Meridian Solar Farm

6.3 ES Appendix 11-3: Flood
Risk Assessment - Annex A

Annex A - Correspondence with the Environment Agency

Figure 7 – 0.1%CC AEP Fluvial Flood Levels extracted from the MIKE Model

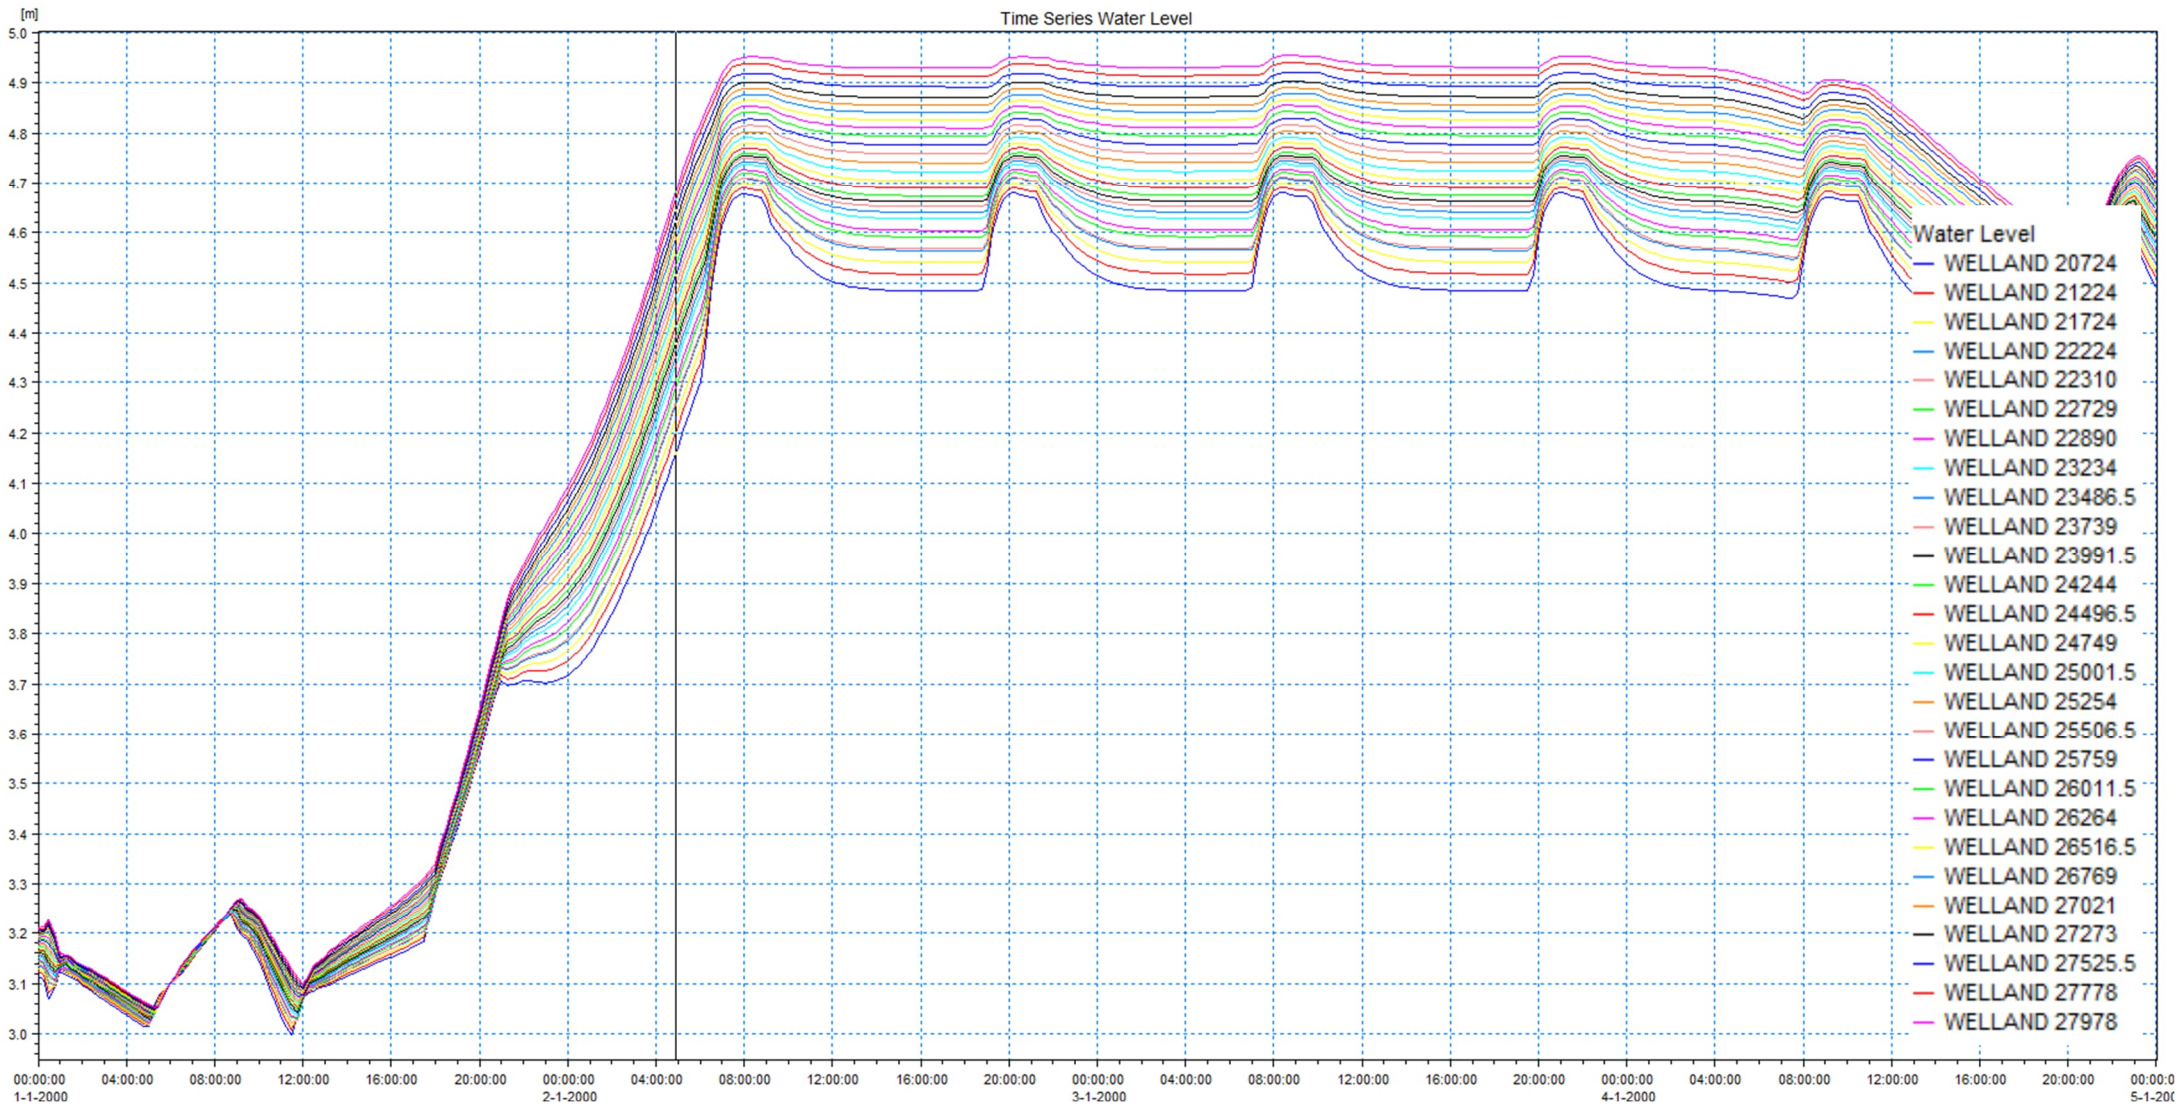
The Environment Agency guidance recommends a time to breach closure of 30 hours for earth banks in rural environments. The reality is in such a location the closure time may be longer than 30 hours. Based on the stage time series data presented in figure 7 it is noted that water levels within the Welland are likely to be elevated over several days. Considering this it would be sensible to test a longer breach duration as a sensitivity test, perhaps 72 hours for one breach location to test the impact on flood risk.

Figure 8 - Proposed Breach Locations

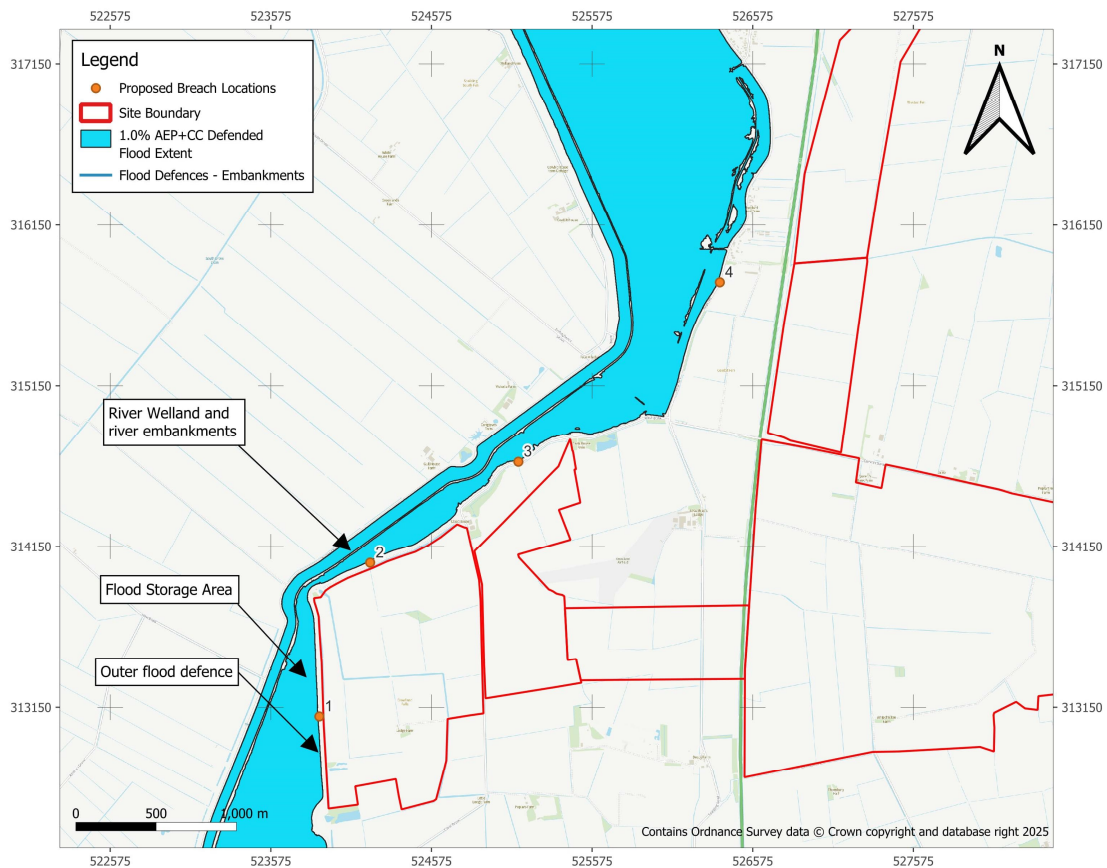
The use of the Environment Agency breach of defences guidance is reasonable in terms of defining breach model parameters. The selected breach locations appear reasonable with respect to the development. Running the four breaches and then merging the outputs together to create a composite breach output is considered reasonable and conservative. The proposal to use breach widths of 50 metres is reasonable and aligns with Environment Agency guidance for earth banks on estuarine/tidal watercourses. The breach trigger level of half the height of the defence and formation duration of 0.1 hours is considered reasonable, particularly noting the defended water levels on the “wet” side of the flood defence embankments. Table 6 of the

breach methodology report defines the breach toe level, defence crest level, breach trigger level, and breach opening duration. We have reviewed the defence toe and crest levels and trigger levels presented within table 6 against the latest 0.25 metre horizontal resolution Lidar data dated 2023. The defence toe and crest elevations and trigger levels presented in table 6 on page 15 of the modelling methodology report are considered reasonable.
